Marine Management Organisation

MMO Reference: DCO/2016/00003
Planning Inspectorate Reference:
EN010084
Identification Number: 20012636

Planning Act 2008, Vattenfall Wind Power Limited, Proposed Thanet Extension Offshore Wind Farm

This document forms the MMO's deadline 5A submission, comprising:

Figure A 10 Contour plot showing the TTS impact ranges for species of fish (Popper et al., 2014) for both modelling locations for both monopile and pin pile scenarios

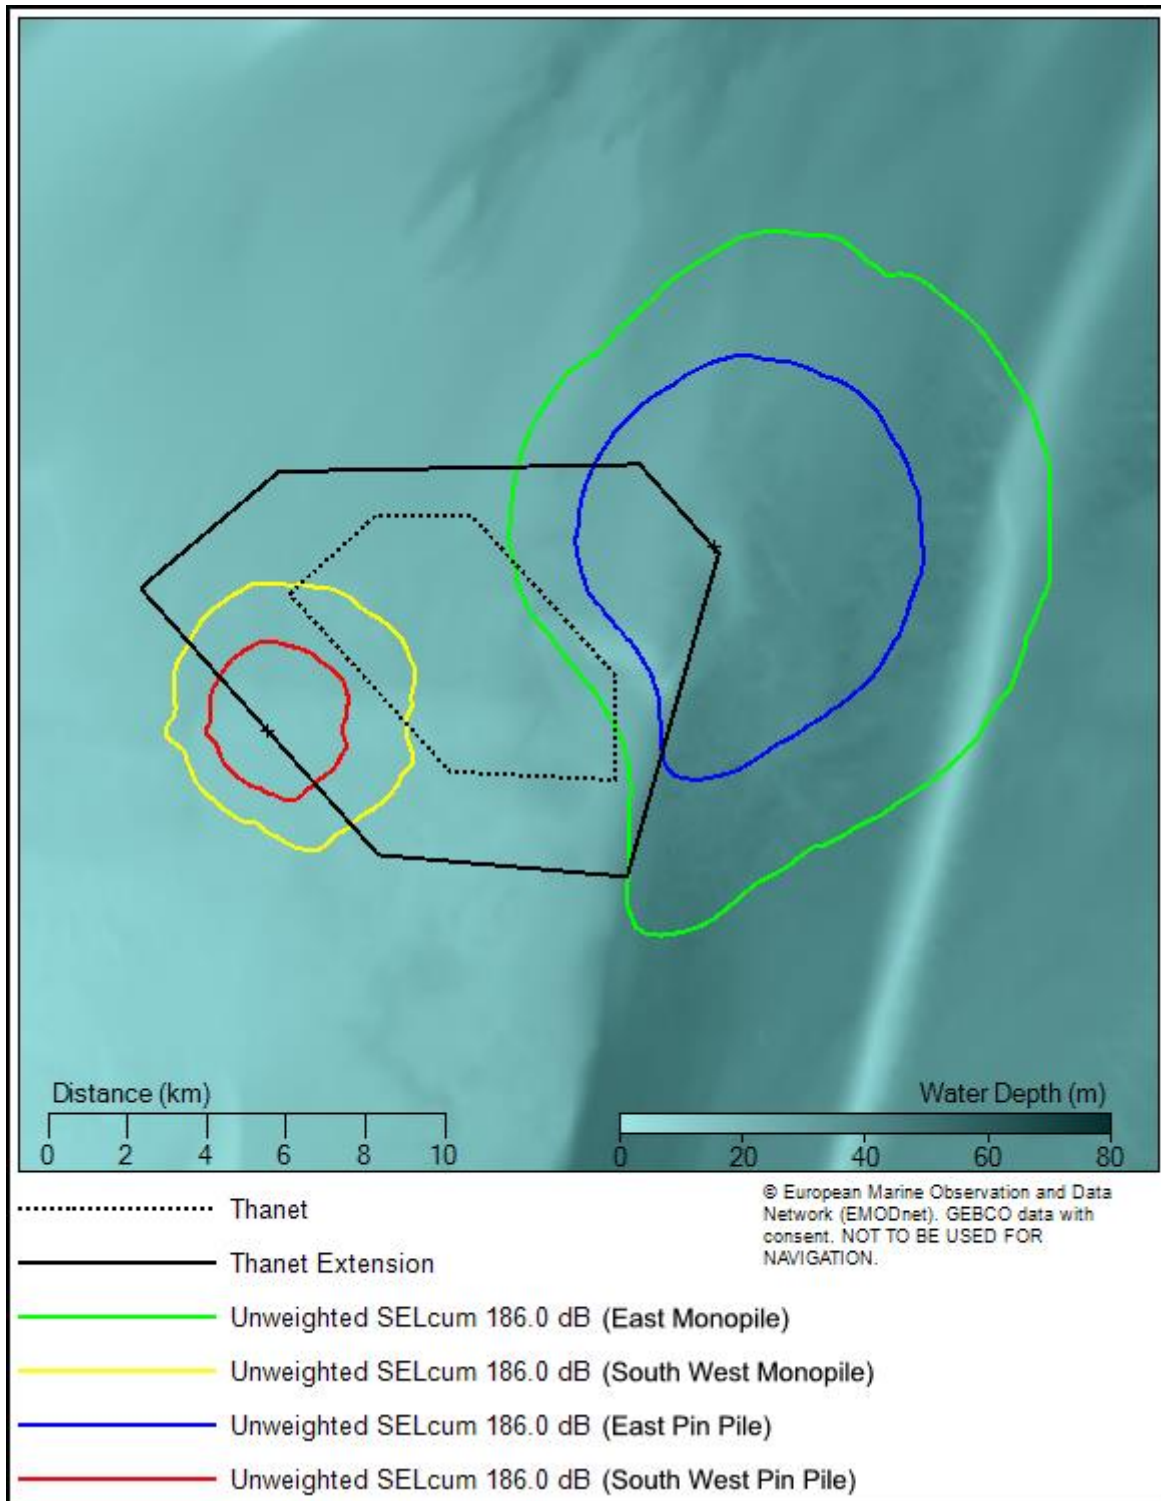
2.2.1 The modelling shows that significantly larger impact ranges are predicted, based on a stationary receptor. The modelling suggests that the predicted impact ranges for mortality, recoverable injury and Temporary Threshold Shift (TTS) (207dB, 210 dB and 186 dB SELcum) will overlap with areas of higher importance for herring spawning (East Channel (Downs) stock). The 186 dB SELcum metric has the largest overlap with the spawning grounds.

2.2.5 The updated modelling demonstrates overlap of the East Channel spawning grounds with the SELcum noise contours (for injury and TTS). Whilst the MMO acknowledges that the IHLS data suggests that the primary spawning is further south, spawning grounds can vary / shift year on year. As a precautionary approach, the MMO recommend that pile driving operations are not permitted during the herring spawning period, to minimise the risk of impact to spawning herring - February to April for the Thames sub-stock, and from the end of November to January for the Downs stock (located to the south in the English Channel).
